BEACON LITE ROAD STOCKPILE – FDR AMENDMENT 1:

COMMENT RESPONSES

October 19, 2026

BEACON LITE ROAD STOCKPILE
PERMANENT CONTROL MEASURE
PLAN - POND "B"

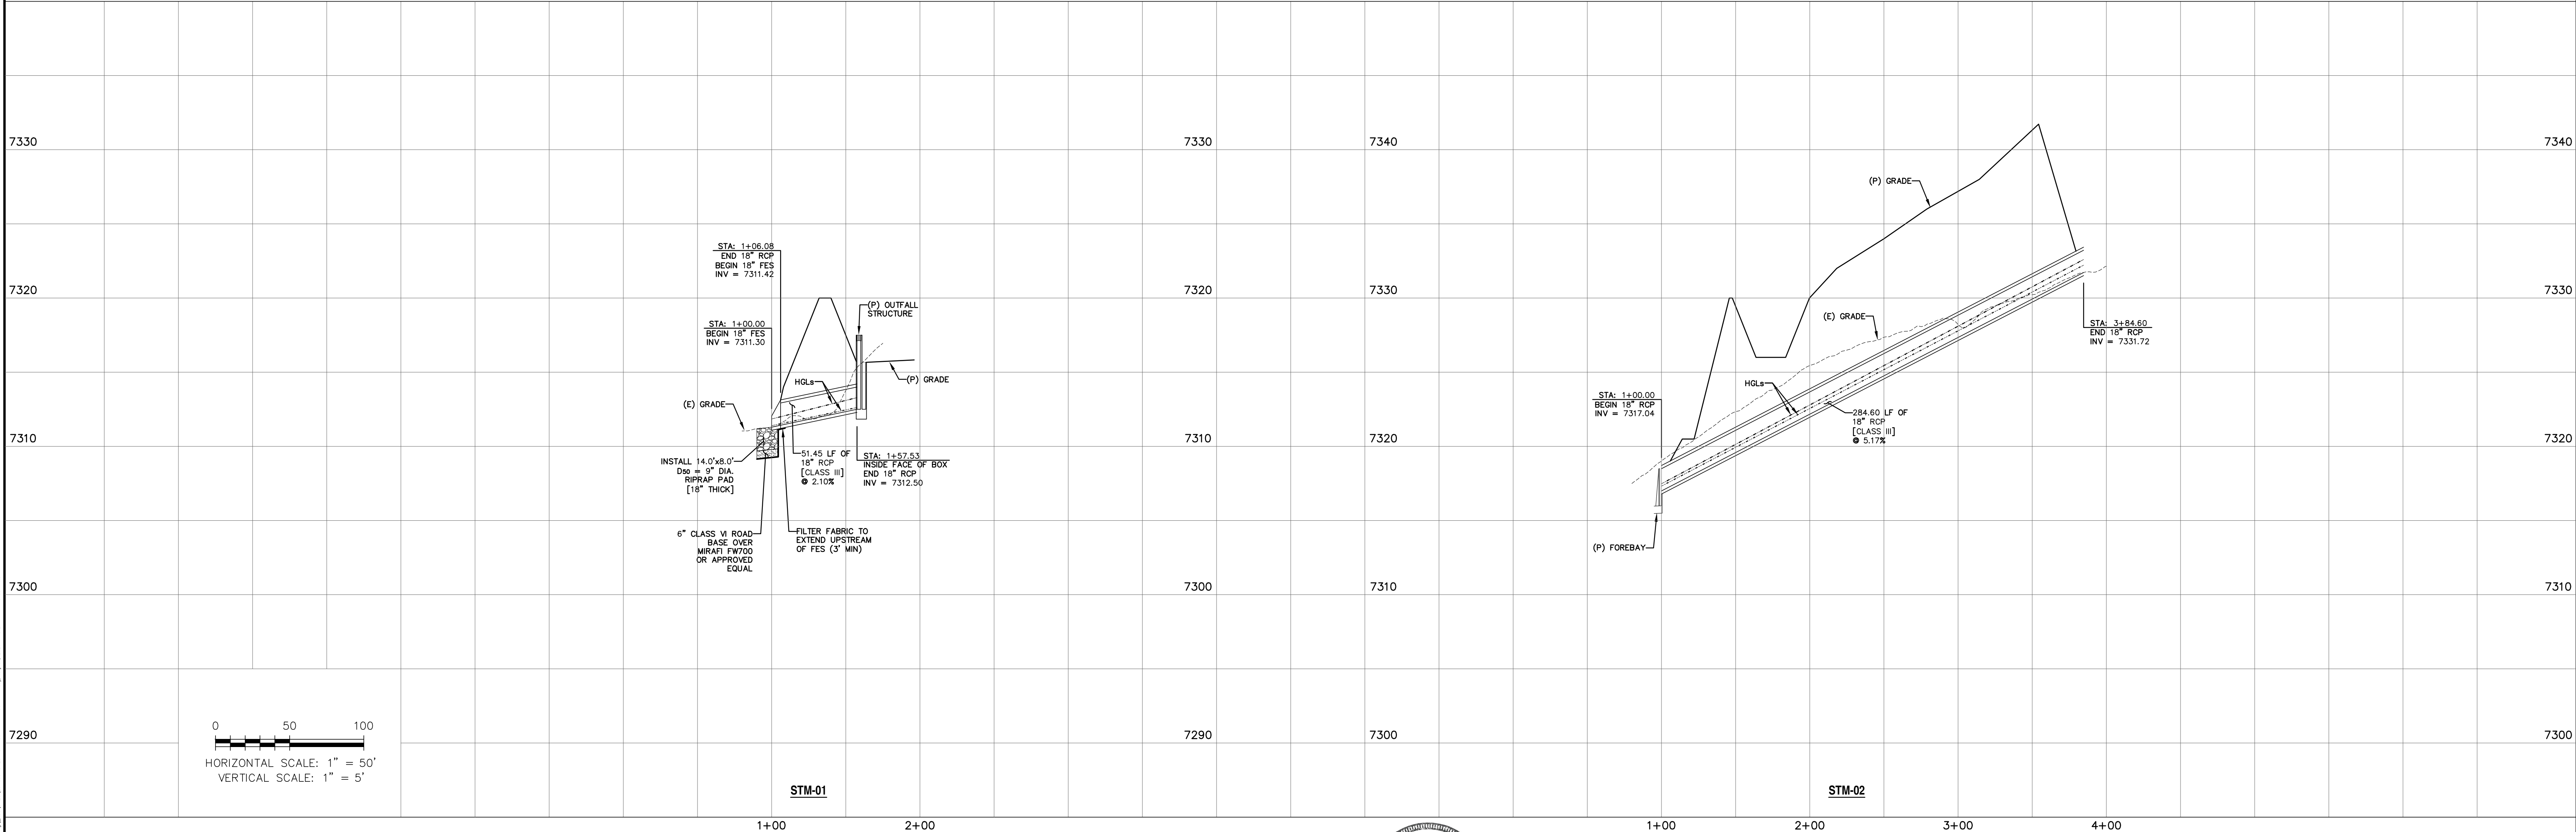
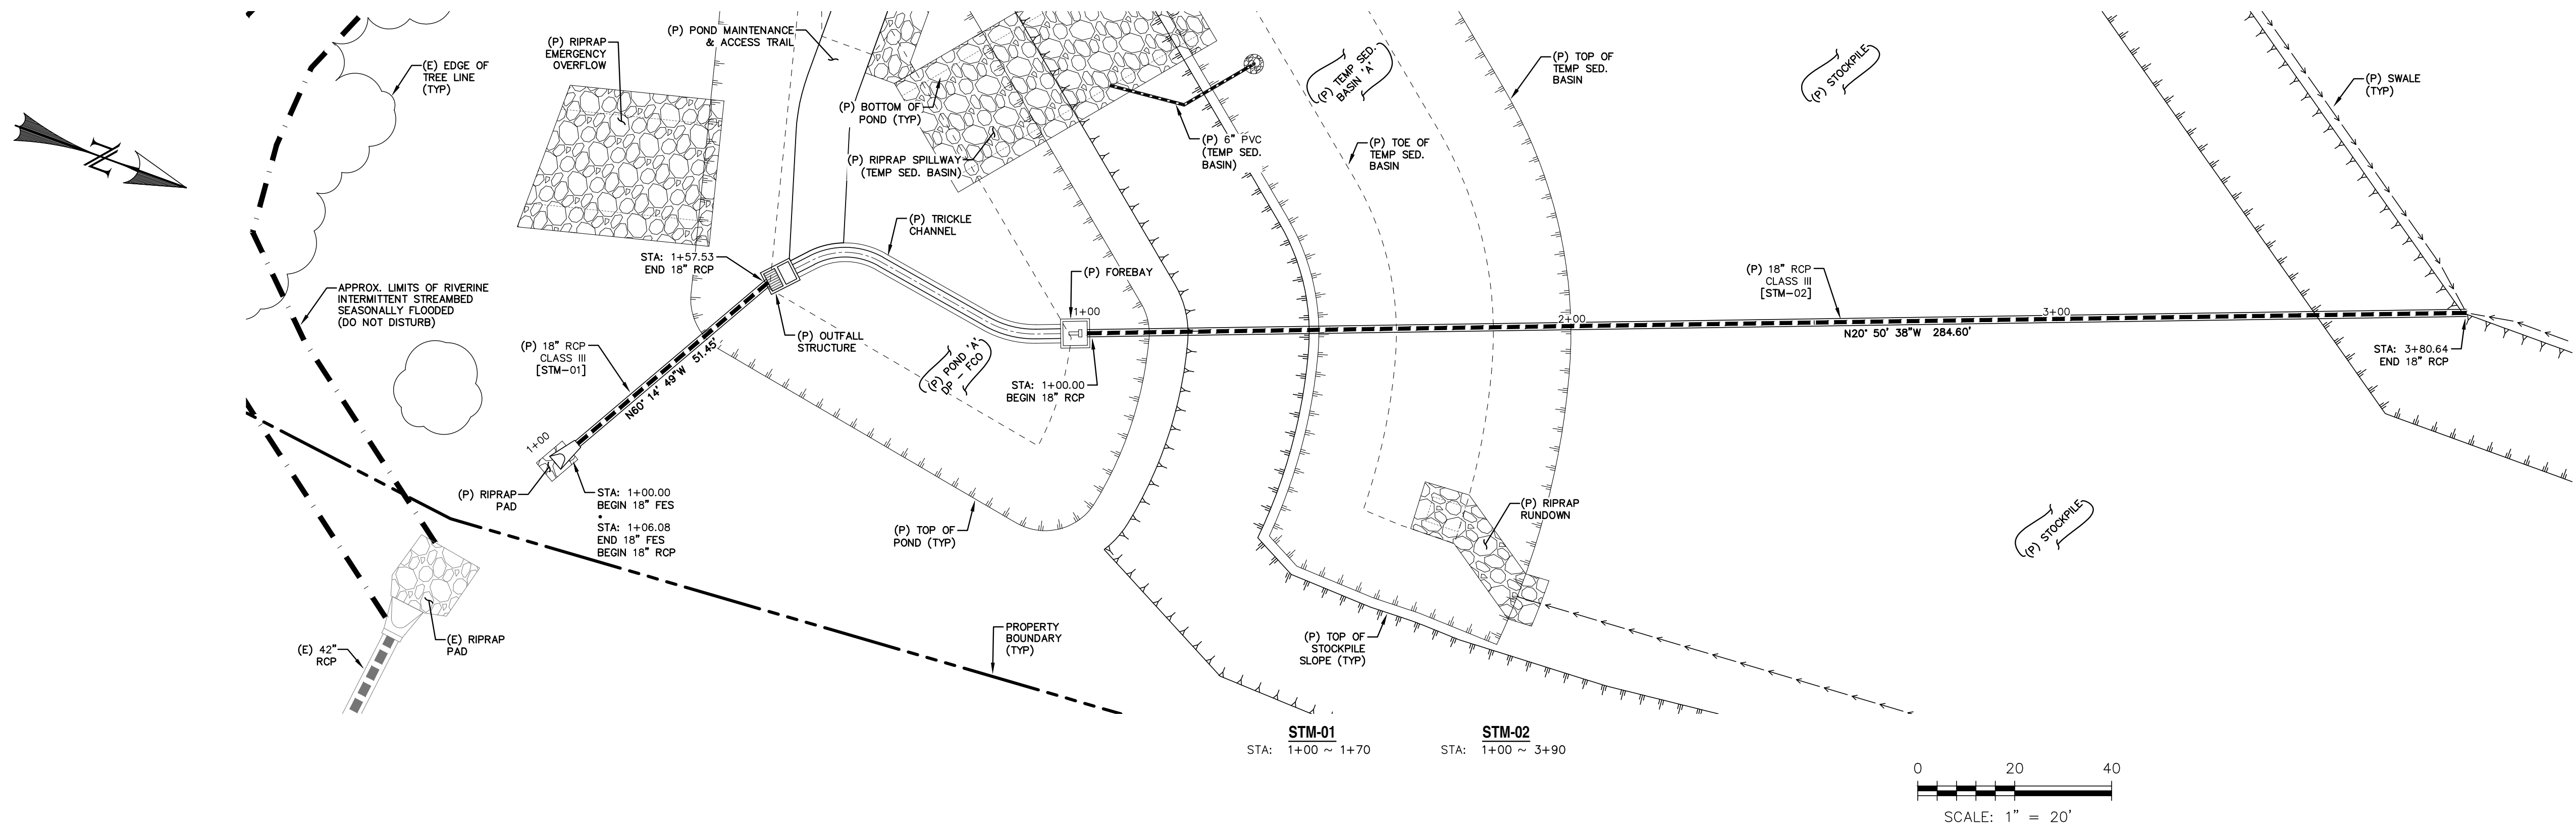
86	17	These diameters do not match what is shown on CDs. [Pond B vertical orifice diameters, Zone 1 and Zone 2, marked X] <i>(Glenn Reese – EPC Stormwater)</i> Response: 0.40in dia. is correct, see CD’s for converted size.
115	18	Update the table accordingly for the design points on the plan sheet. <i>(Daniel Torres)</i> Response: Revision made.
116	19	Please show all missing items on the plan. <i>(Daniel Torres)</i> Response: Revision made.
117	20	Please show all the existing TSB items that are missing. <i>(Daniel Torres)</i> Response: Revision made.
